From: Paul Cann
Sent: 02 August 2017 15:31
To: Planning.Responses
Subject: RE: Planning Consultation on: CM/23/17/PL

Surface water drainage comments:

APPLICATION CM/23/17/PL

Description of Works: Erection of 1 No. dwelling with detached garage (resubmission of CM/29/14/PL). This application is a Departure from the Development Plan.

Site Plan

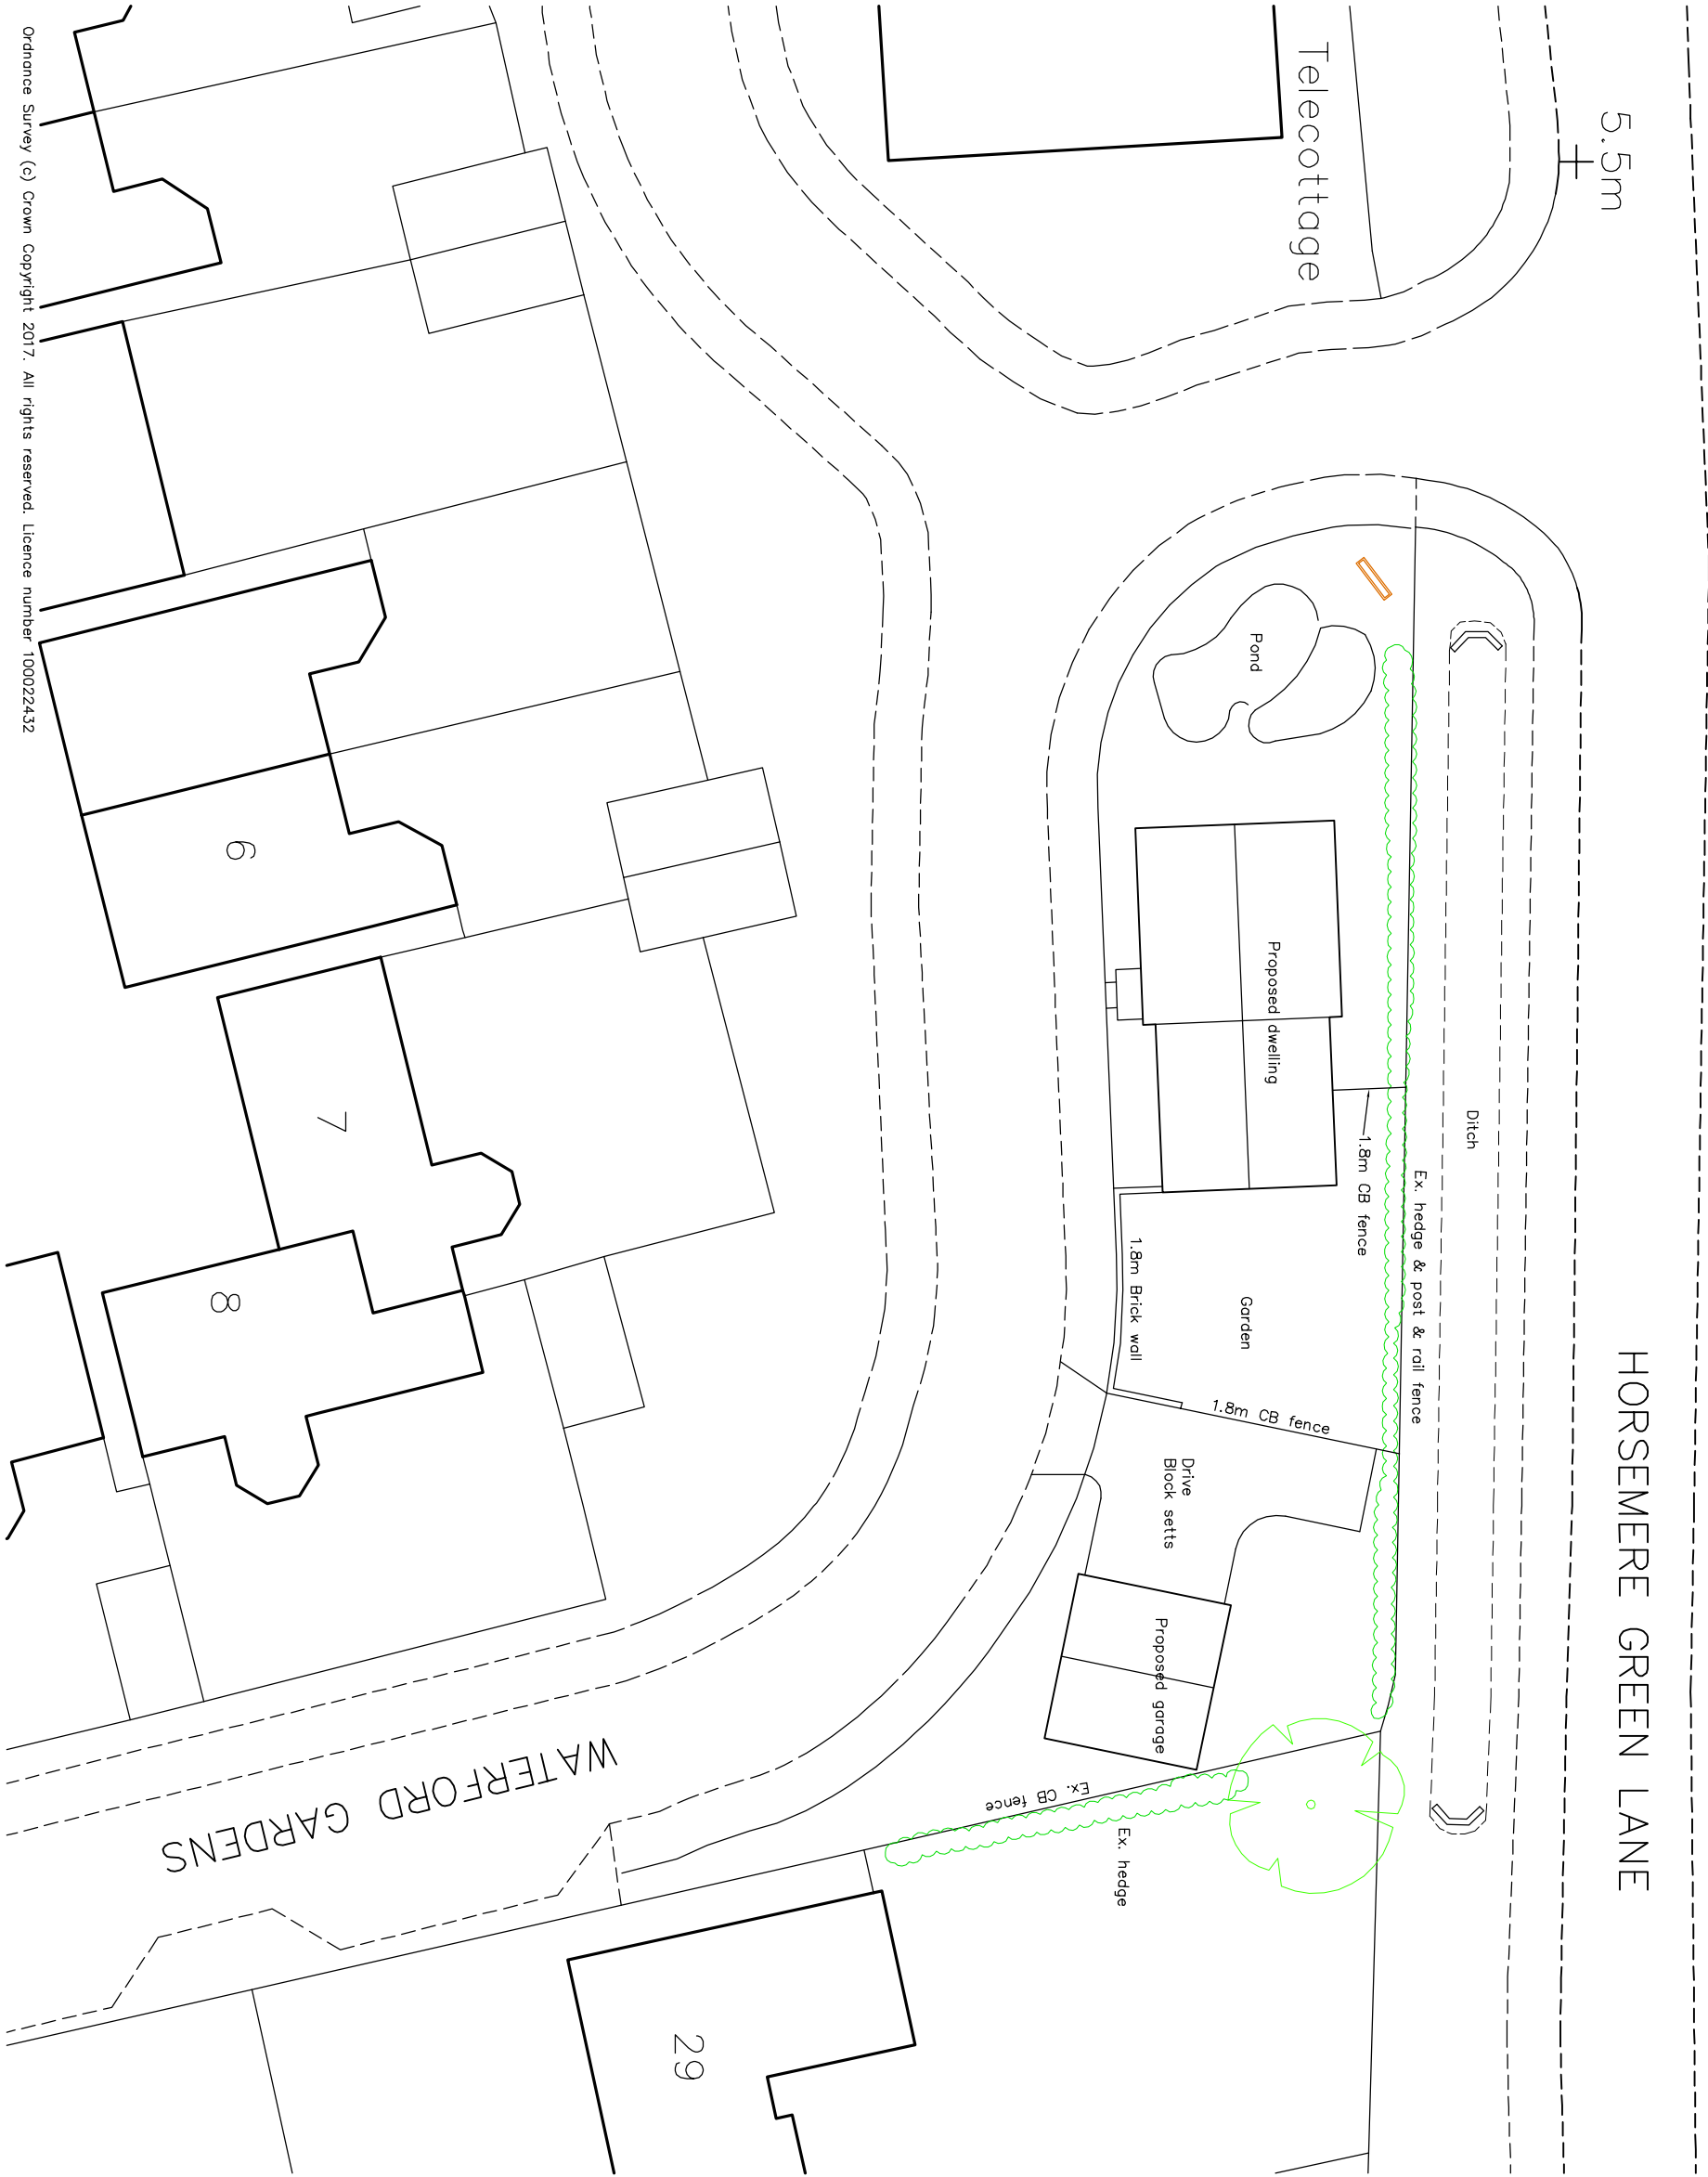
The applicant should investigate the disposal of surface water to ground via infiltration. The design will need to be agreed with Building Control.

There is a watercourse adjacent the plot, please could standard condition 4A be applied, just in case infiltration proves not to be feasible and that a connection to the watercourse is required.
